Charlotte Department of Transportation

Memorandum

Date: March 28, 2008

Subject: Rezoning Petition 08-068: Located on the northeast corner of Eastfield Road and Highland Creek Parkway

RZ-1

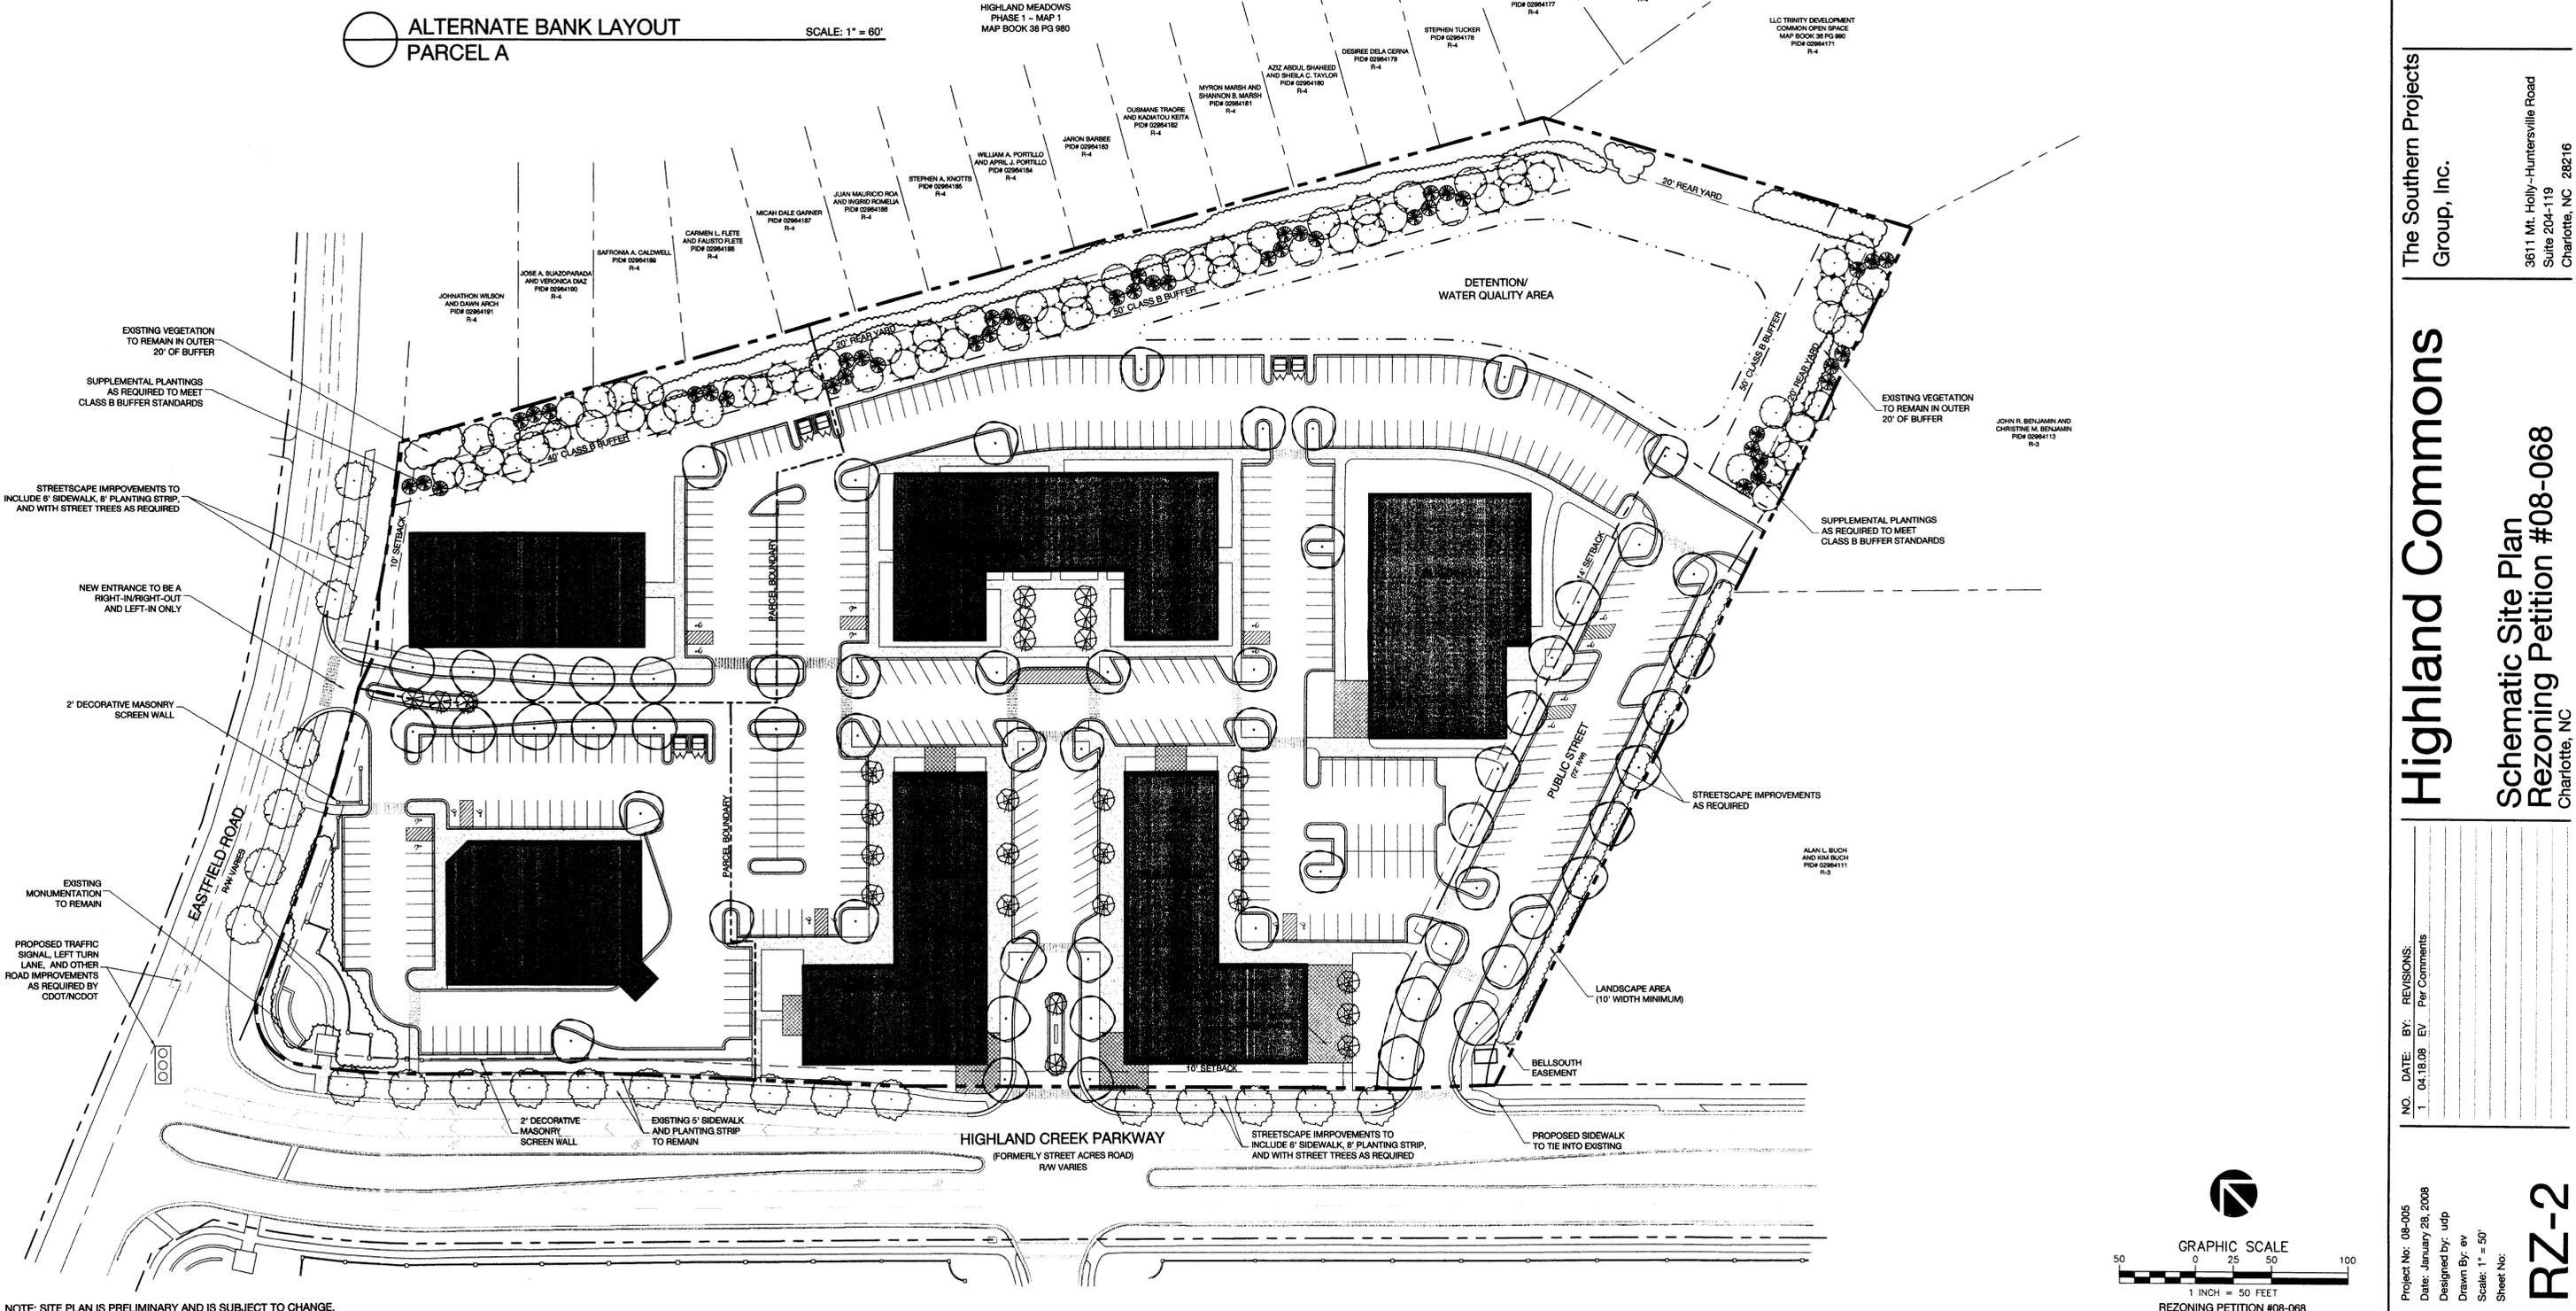
- a. Southbound Eastfield Road left-turn lane at Highland Creek Parkway with 250 feet of storage and otherwise designed to NCDOT standards.
 - b. Installation of traffic and pedestrian signals at the Eastfield Road/Highland Creek Parkway intersection when traffic signal warrants are met and along with other considerations both CDOT/NCDOT determine that traffic signals need to be installed.

- d. Relocate the existing Highland Creek Parkway crosswalk closer to the intersection so that it can safely operate under signal control.
 - e. New internal public street(s) is constructed to connect the site to adjacent properties so that all trips are not required to access the site unnecessarily from Eastfield Road and Highland Creek Parkway. At least one public street must be provided opposite Falconcrest Drive that stubs to parcel #029-641-13. This public street will be extended with redevelopment of adjacent property and will connect with future extensions of Cambridge Bay Drive, Bernardy Lane (Huntersville), and other new public streets. This street is to be designed to the Local Office/Commercial Street-Wide cross section in accordance with the adopted Urban Street Design Guidelines (USDG).

2. In accordance with the existing conditional plan for this site, no access will be approved to Eastfield Road. Access to the site will be limited to the existing/planned access location on Highland Creek Parkway that includes an eastbound left-turn lane. Eastfield Road is a state-maintained road. The NCDOT will not approve direct access to Eastfield Road from this site.

3. 8-foot planting strips and 6-foot sidewalks must be constructed along all public streets, even if there is existing sidewalk. The existing planting strip along Highland Creek Parkway appears to currently meet this requirement.

Eastfield Road is an Avenue requiring a minimum of 120 feet of right-of-way. The developer/petitioner should convey right-of-way in fee simple title to meet this requirement, measuring 60 feet from the centerline of the roadway.

Adequate sight triangles must be reserved at the existing/proposed street entrances. Two 35' x 35' and two 10' x 70' sight triangles are required for the entrances to meet requirements. All proposed trees, berms, walls, fences, and/or identification signs must not interfere with sight distance at the entrance(s). Such items should be identified on the site plan.
